Ref 2023 0919 – Listed Building Consent

Proposal: Alterations to the existing retail unit to provide a new disabled access toilet, baby changing facility and a cleaners store including the removal of existing internal doors, replacement of external door with minor widening to allow clear opening width of 1m, privacy film to external windows, new internal partitions, new sanitary ware and associated mobility furniture, ceiling hoist and building services (Listed Building Consent)

Address: Building B12, Elsecar Heritage Centre, Blacksmith Square, Elsecar, Barnsley S74 8HJ

Proposed Elevation B - Scale: 1:50

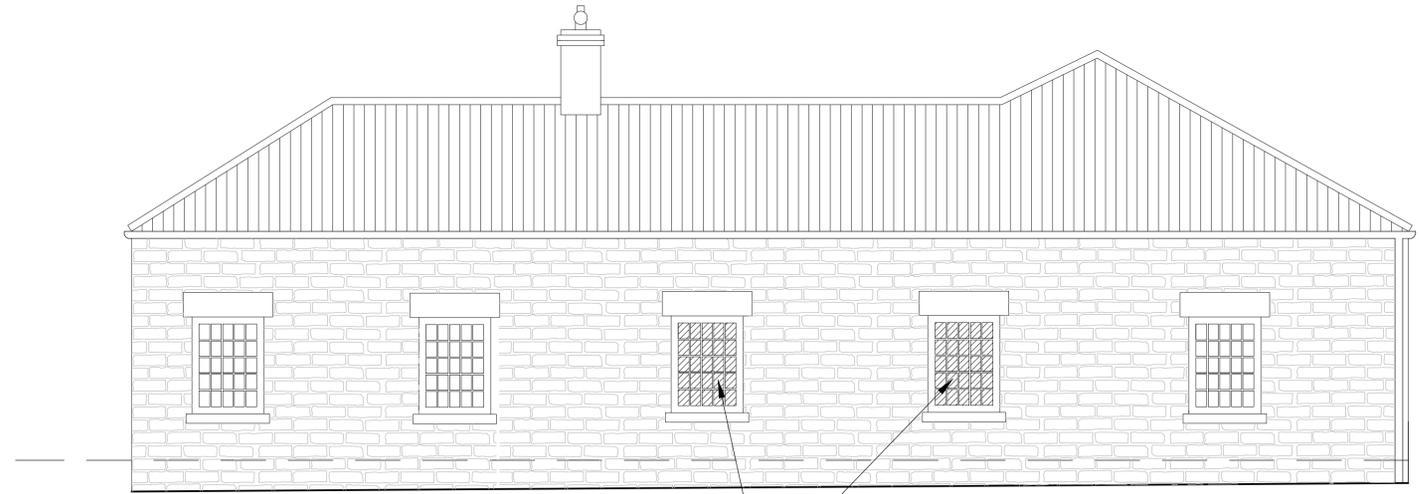
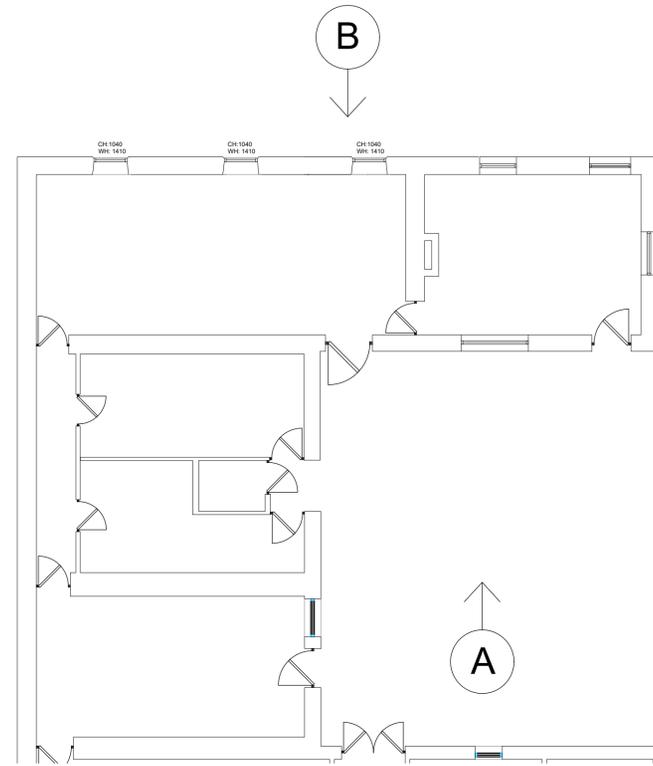
Conservation – The main issues to be considered are whether or not the proposed alterations would harm the special architectural or historic interest or impact on the setting of the listed building; and in relation to the Conservation Area setting, to have special regard to the desirability of preserving the building or its setting or any features of special architectural or historic interest which it possesses. The site is of elevated special interest due its grade of listing. However, this part of the site underwent alterations in the 1990s to alter and extensively refurbish the internal spaces. The interior is of limited heritage interest, and I see little negative impact in the proposal in terms of the internal changes and little likelihood of harm; and the lightweight partitions, internal door infilling and privacy vinyl on the windows being reversible. The external door and frame are clearly modern and there is no concern with replacement, but care needs to be taken with any minor widening that may be necessary to secure a clear opening width of 1000mm

Councillor Richardson that the door be designed more in keeping with the rest of the estate rather than a modern style.

The design of the external door has been amended to show a plain vertically boarded door (ie removal of the originally proposed mid-level horizontal panel) which has a more traditional appearance.
